WEST SUSSEX COUNTY COUNCIL CONSULTATION

TO:	Arun District Council FAO: David Easton
FROM:	WSCC - Highways Authority
DATE:	30 November 2021
LOCATION:	Land West of Pagham Road Pagham
SUBJECT:	P/155/21/RES Approval of reserved matters (layout, scale, appearance and landscaping) following outline consent P/140/16/OUT for the 'local centre' parcel which comprises of retail, community and commercial uses, 20 No residential apartments and a 70 bed care home.
DATE OF SITE VISIT:	n/a
RECOMMENDATION:	More Information
S106 CONTRIBUTION TOTAL:	n/a

Proposed Site Layout, drawing no. 10165 PL 01 rev C
Transport Statement, dated October 2021

Figure 5.1 – Proposed local centre access arrangements and spine road treatment

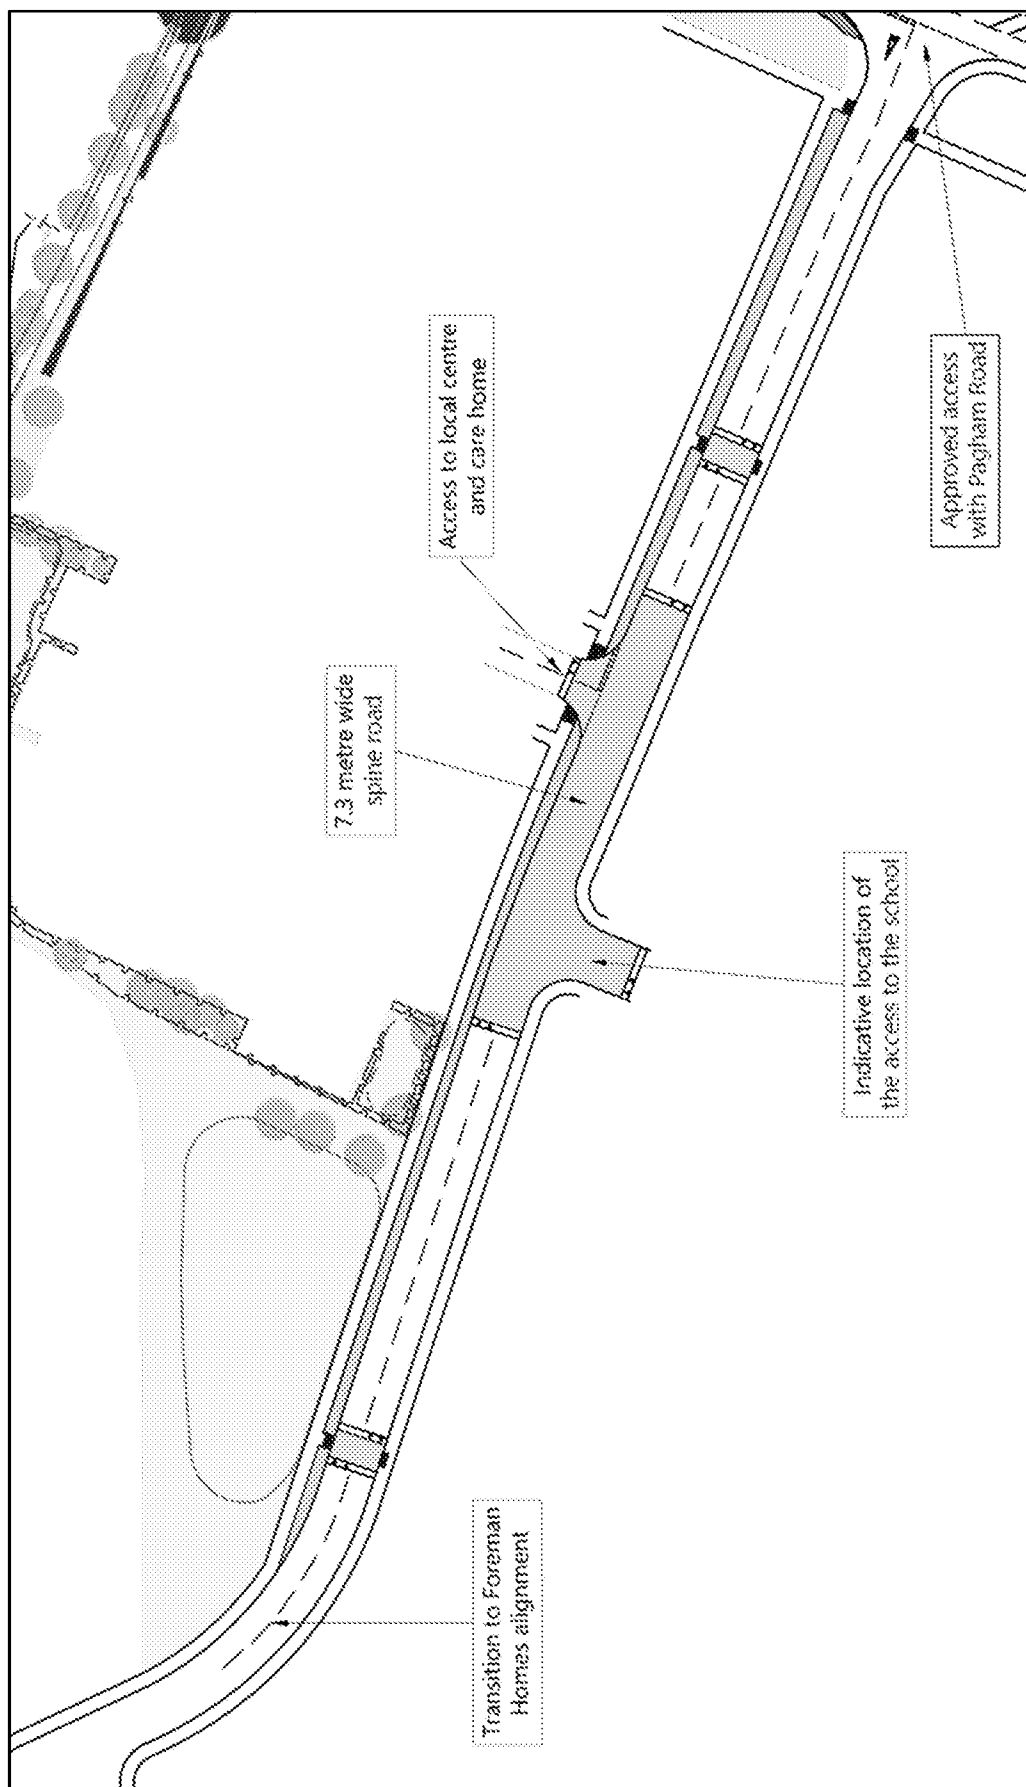
In terms of more detailed matters, WSCC Highways have previously questioned the need for the 7.3 metre wide road across the school frontage; this road width is considered at odds with the 20mph design speed proposed. This aside, very limited consideration appears to have been given particularly to the potential demands arising from the school site (i.e. parent parking, dwell space/footway widths along the frontage) or the need for school safety zone type features (e.g. enforceable restrictions (i.e. 'School Keep Clear and No Waiting At Any Time (which may need to be wrapped around onto Pagham Road also). The applicants for P/153/21 and the current application will need to incorporate such elements into the design.

It's also recommended that the single raised feature to the west of the raised feature incorporating the community uses and school accesses are combined to form a single feature across the school/community use frontages. The single short raised feature in isolation serves little purpose particularly given it's close proximity the longer raised table.

Architect's Plan of the Proposed Local Centre

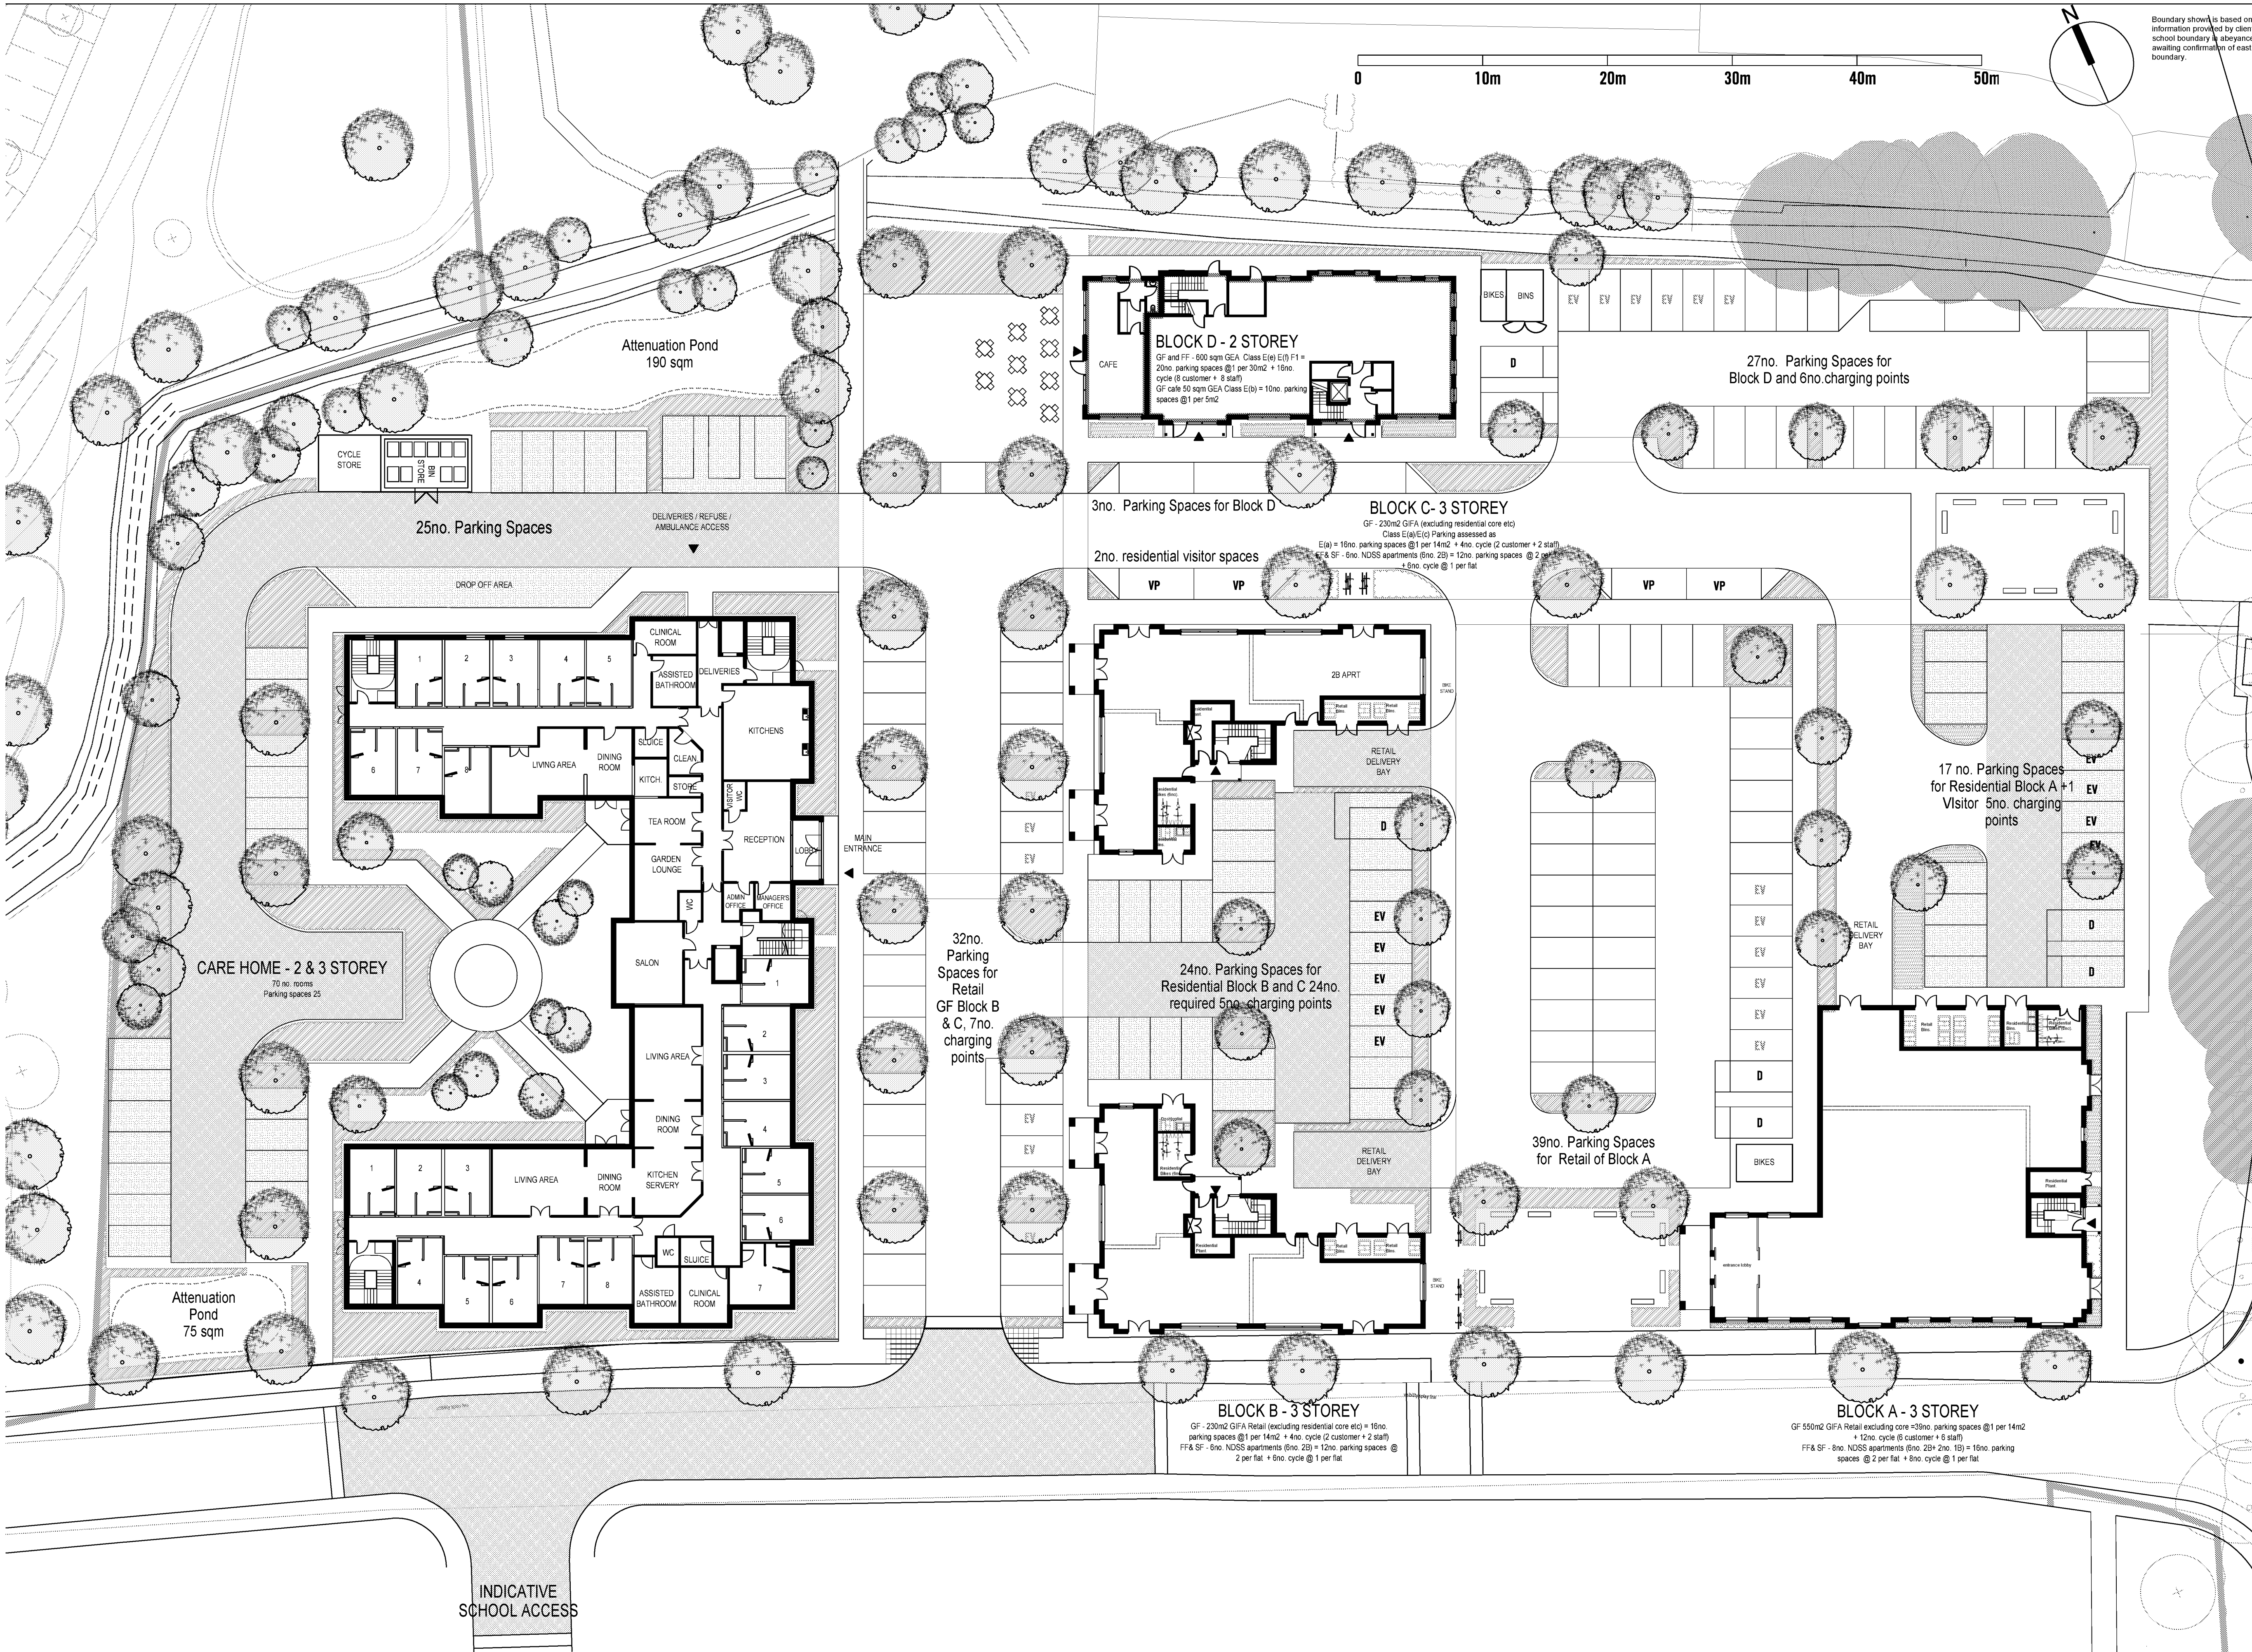
The internal layout highway-wise effectively comprises car parking for the various uses. Manoeuvring for a 11 metre wide refuse vehicle is demonstrated around the site.

Limited details are presented of servicing provisions for the retail uses. These won't however be known until the occupier of the retail units are known. It's recommended that a servicing management plan is secured via condition for the retail uses. The management plan should include all pertinent details surrounding deliveries to the retail unit, including the size of vehicle to be used.

The level of car parking is understood to comply with the Arun District Council standards. For the care home, 25 parking spaces are proposed. It's recognised that there is no parking standard for care homes. Parking provision has consequently been considered on a first principles basis although it's not entirely clear exactly how the number of spaces has been determined. The TS and Site Layout refers to 5% of spaces being for disabled users. There is notably no disabled parking for residents or visitors to the care home. It's not unreasonable to expect that there may be some visitors to the care home that would need disabled parking provision.
